**MODIFICATION REQUEST:
Enfield Intermodal Logistics Centre -
Modification 5
Cosgrove Road, Strathfield South
(MP 05_0147 MOD 5)**

Onsite relocation and reuse of excavated material deemed unsuitable for engineering fill at the Intermodal Logistics Centre operational areas to the southern part of the site.

Director-General's
Environmental Assessment Report
Section 75W of the
Environmental Planning and Assessment Act 1979

October 2011

FIGURE 1.2
ILC AT ENFIELD
LOCATION OF FILL REUSE AREA

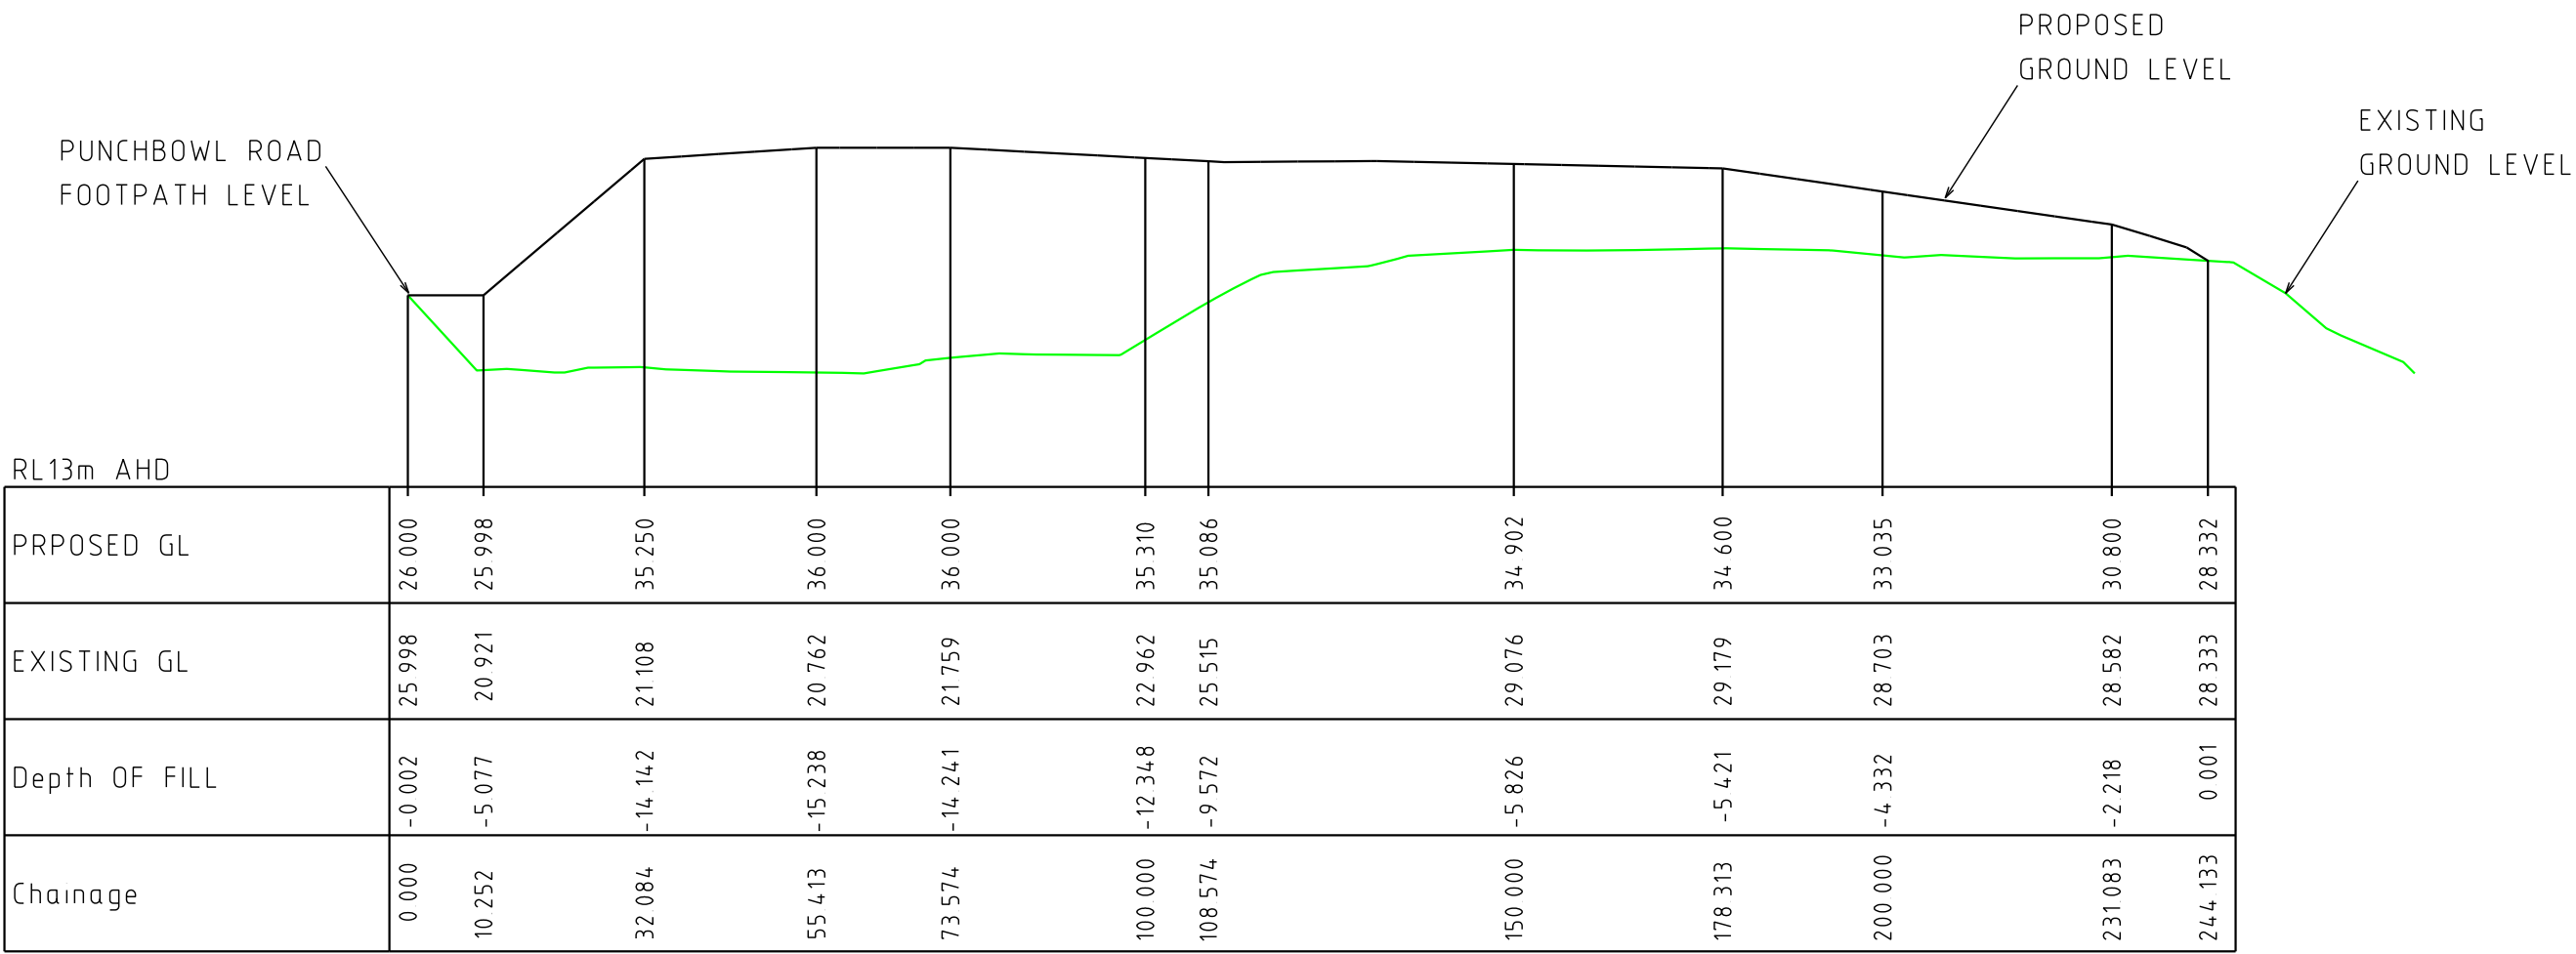
Office of Environment and Heritage – Environment Protection and Regulation Team: raised concern with the gradient of the proposed slope of the filling area, and considered it to be in excess of the recommended slope for stockpiling as detailed in *Soils and Construction: Managing Urban Stormwater* (Landcom 2004). OEH recommended a management plan to manage the steep batters during construction and until stabilised, and provided commentary and recommendations in relation to covering soil, water and dust issues.

Accordingly, the Department acknowledges that management of steep slopes during the 18 month construction period for the reshaped Mt Enfield will require specific mitigation measures in response to the potential for erosion and dust impacts. The Department considers that whilst the CEMP and Soil and Water Management Plan would contribute to managing erosion and sedimentation issues associated with construction of the earth mound, additional specific management measures are required to ensure that potential impacts that could occur as a result of the exposed steep slopes during construction are managed.

FIGURE 1.3
ILC AT ENFIELD
FILL REUSE AREA LONG SECTION

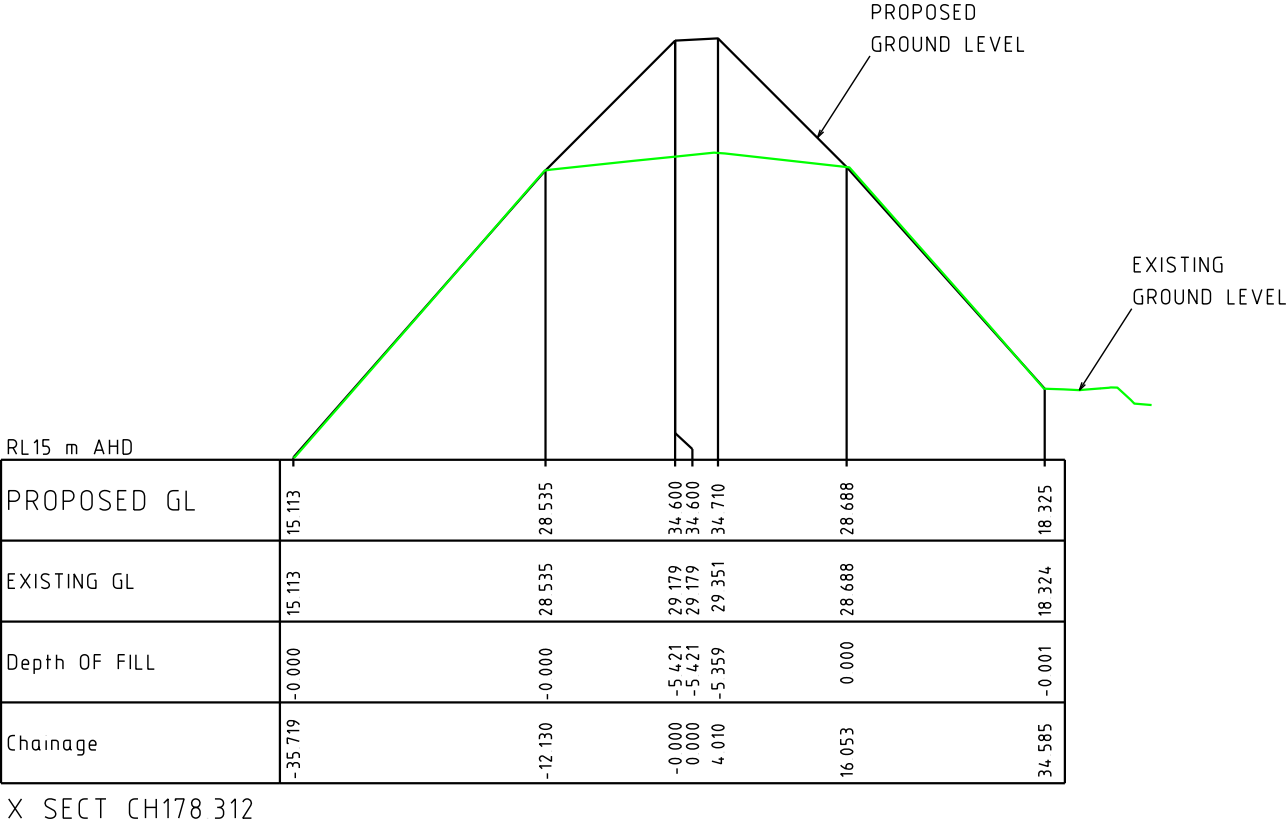
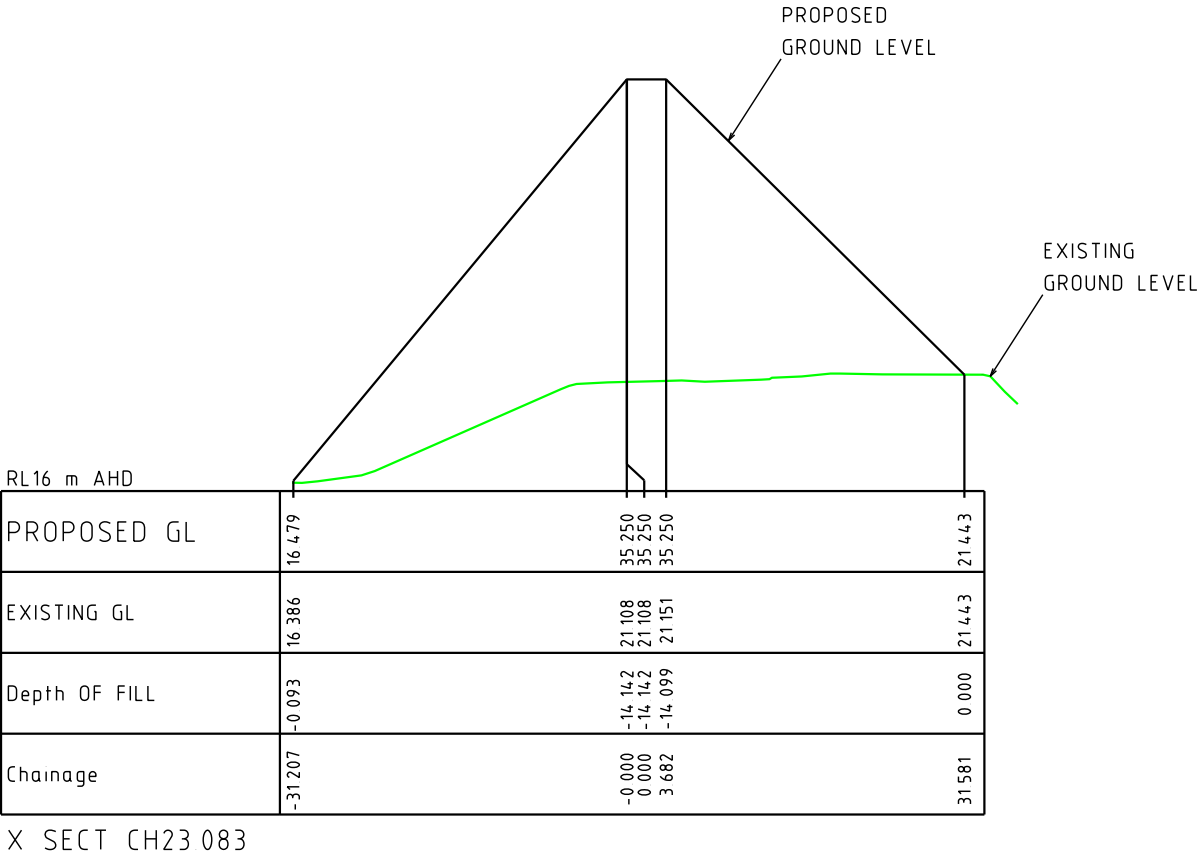
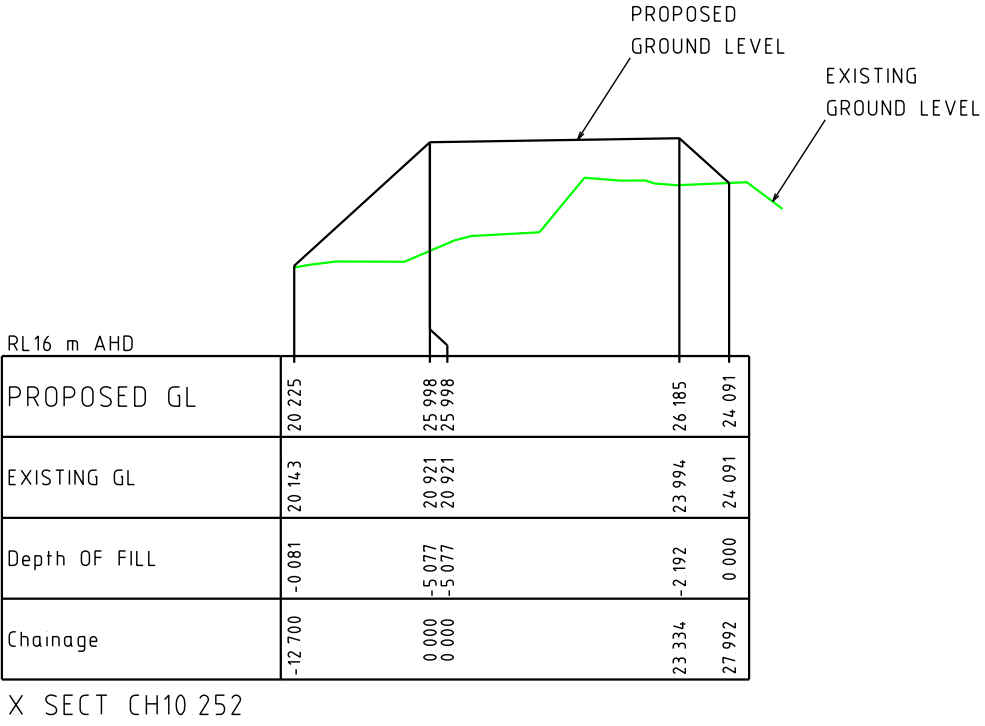
Council considered that the proposed mound with its steep slopes should not be permitted, due to high risk of scouring and sediment loss particularly in rainfall events, as the slopes are too steep to accommodate suitable grading for planting. Council also noted that the modification request did not clearly demonstrate where the runoff from the proposed mound would be directed to, and that ponding and flow paths for runoff should be provided to demonstrate that additional runoff volume and velocity had been investigated and allowed for. Council noted that drainage from the site needed to be controlled so that there would be no additional stormwater leaving the site at each point of discharge than occurred prior to the proposed development.

The Department notes concern raised by OEH and Strathfield Council regarding the steepness of the slope and the subsequent stabilisation issues including that it may be too steep for planting and pose scouring and sediment loss impacts during rainfall events.

The Department notes that *Soils and Construction: Managing Urban Stormwater* recommends a maximum of 1V:2H slopes for stockpiles, and notes that rehabilitating steeper slopes of >1V:2.5H by vegetative means can be difficult, but provides guidelines for additional methods to allow for the effective stabilisation of steeper slopes.

The Department therefore recommends a condition of approval requiring preparation of a Mt Enfield Stabilisation Management Plan to specifically address management of the steep batters of Mt Enfield during construction and until such time as it is stabilised with vegetation. The stabilisation plan is also required to include consideration of soil, water and dust issues.
